# CITY OF ALBUQUERQUE

September 27, 2021

**Re: La Vida Llena, Phase 2**  
**10501 Lagrima De Oro Rd NE**  
**60-Day Temporary Certificate of Occupancy**  
**Transportation Development Final Inspection**  
Engineer's/Architect's Stamp dated 10-30-19(DRB) (F21D028)  
Certification dated 9-15-21

SP-EPC-3

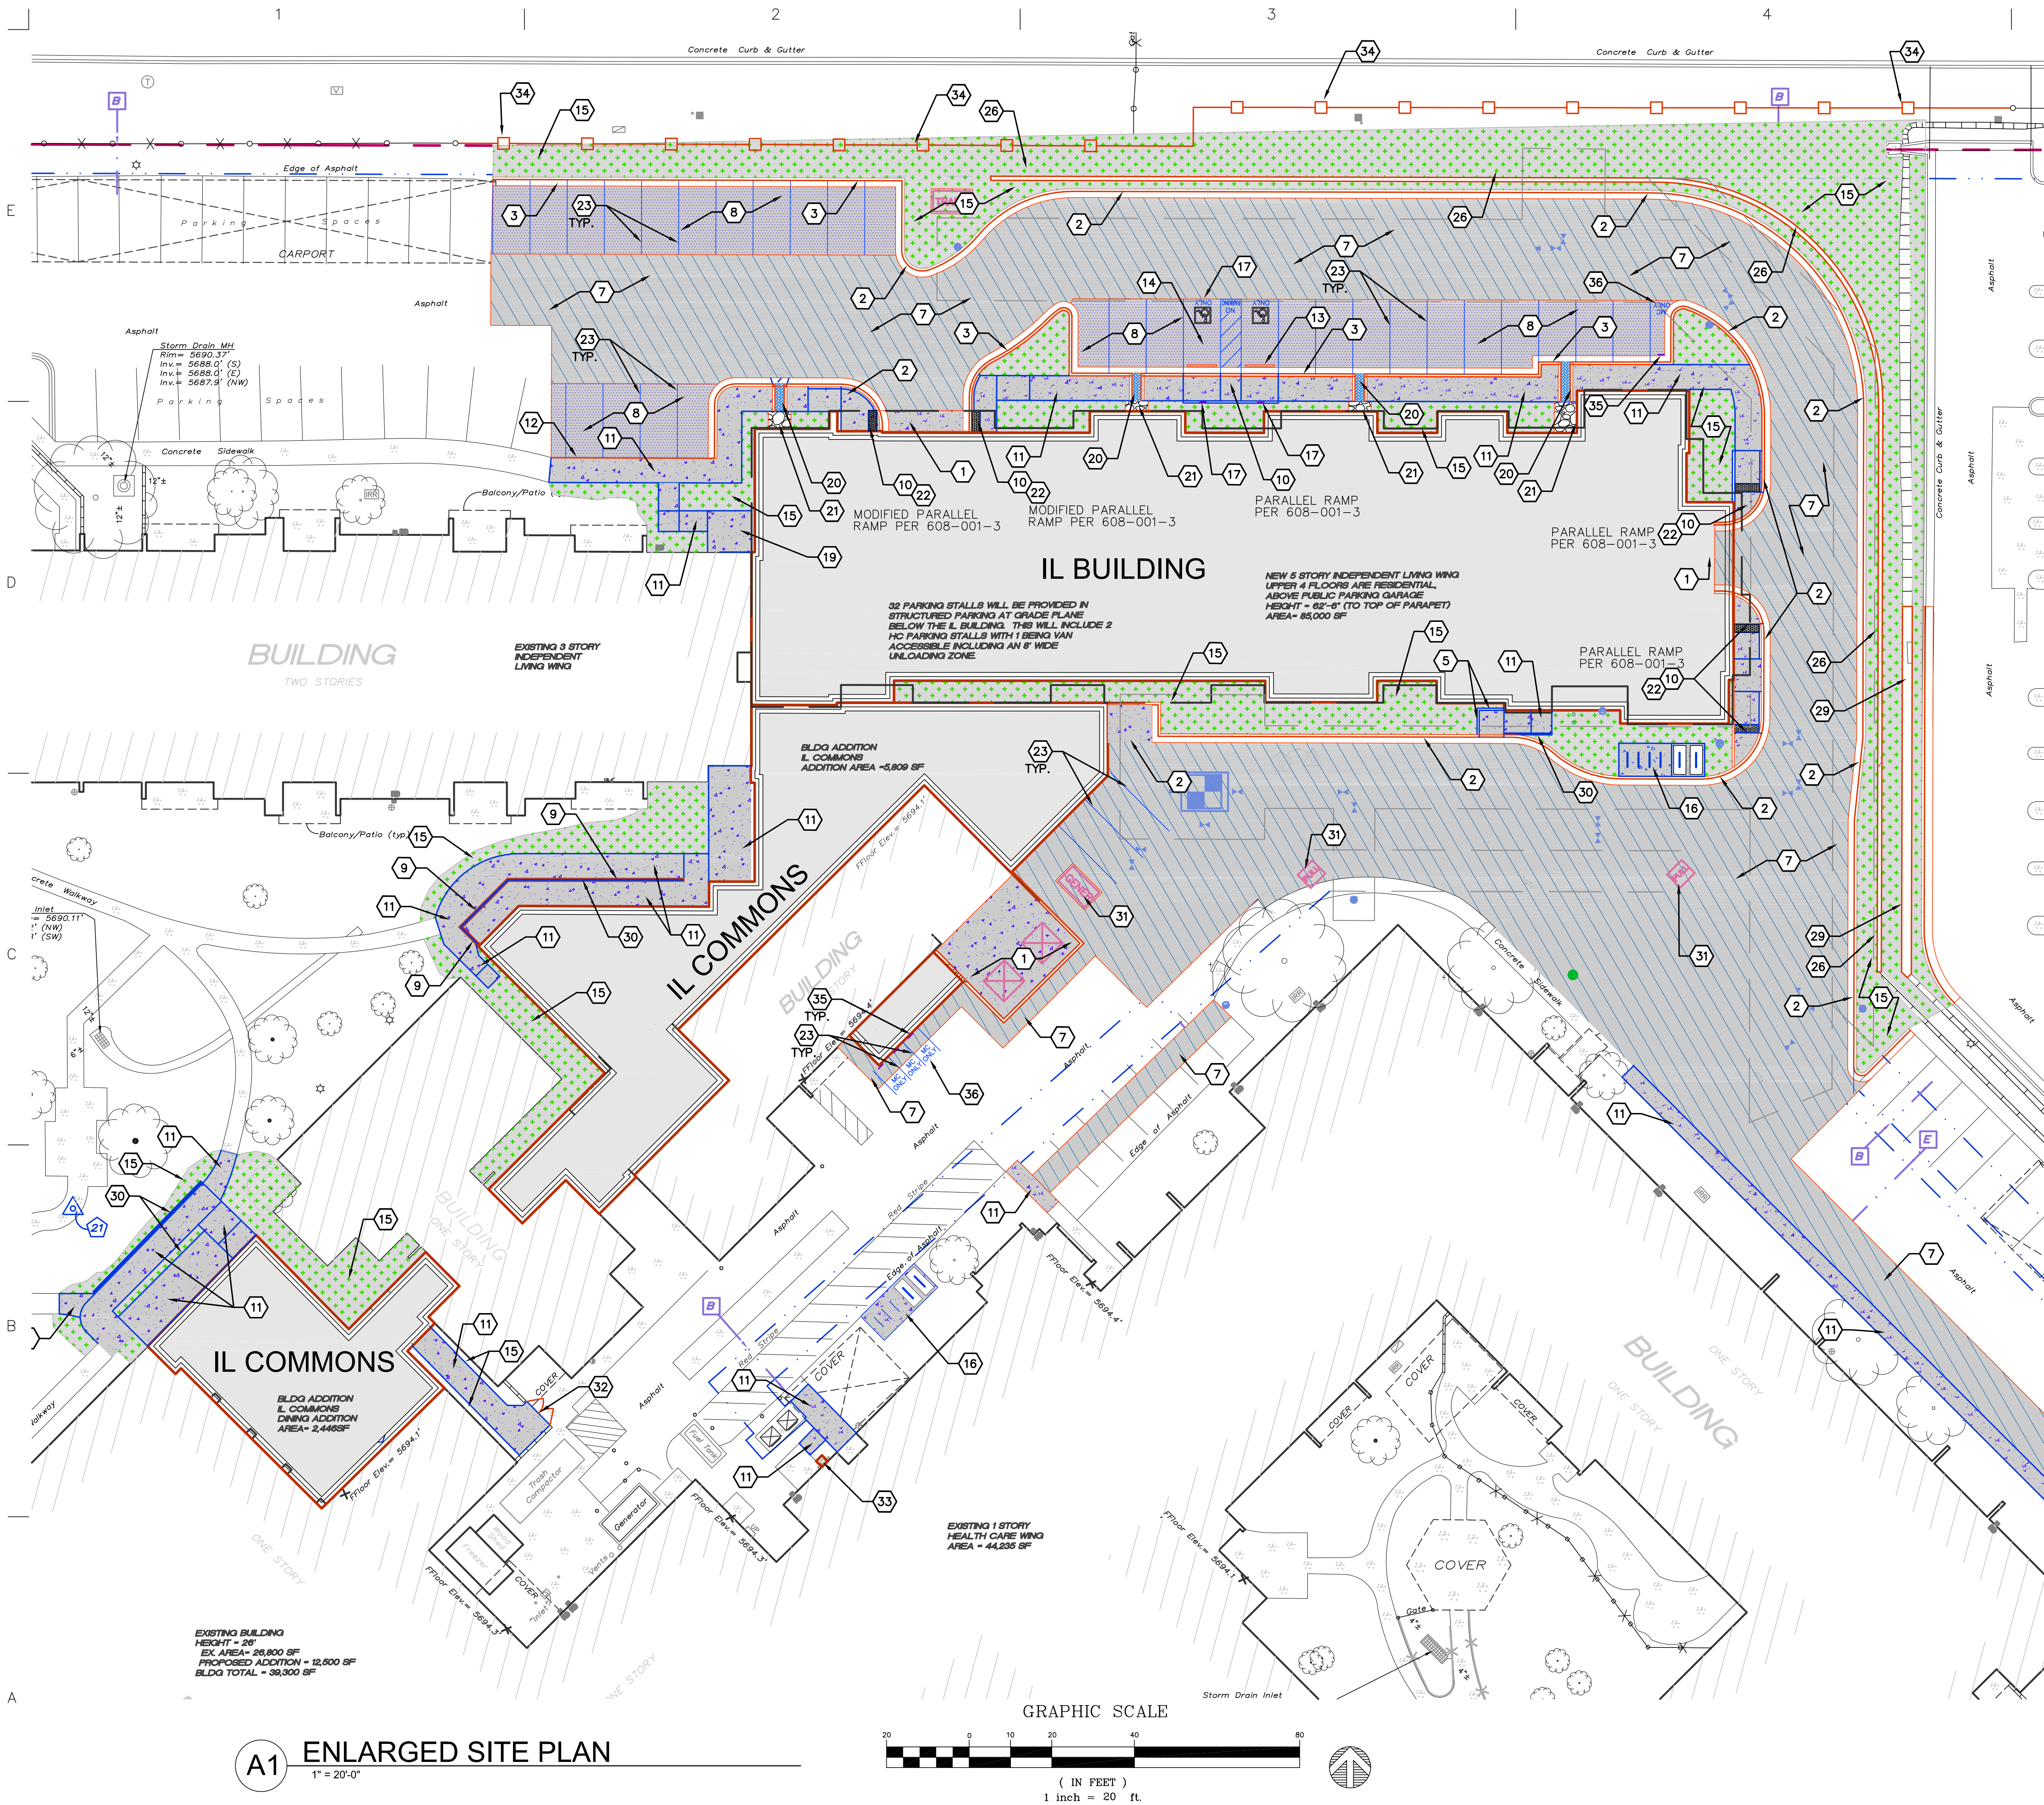
- Please add Motorcycle Signs.
- Remove security fence, porta potties and construction equipment and debris.
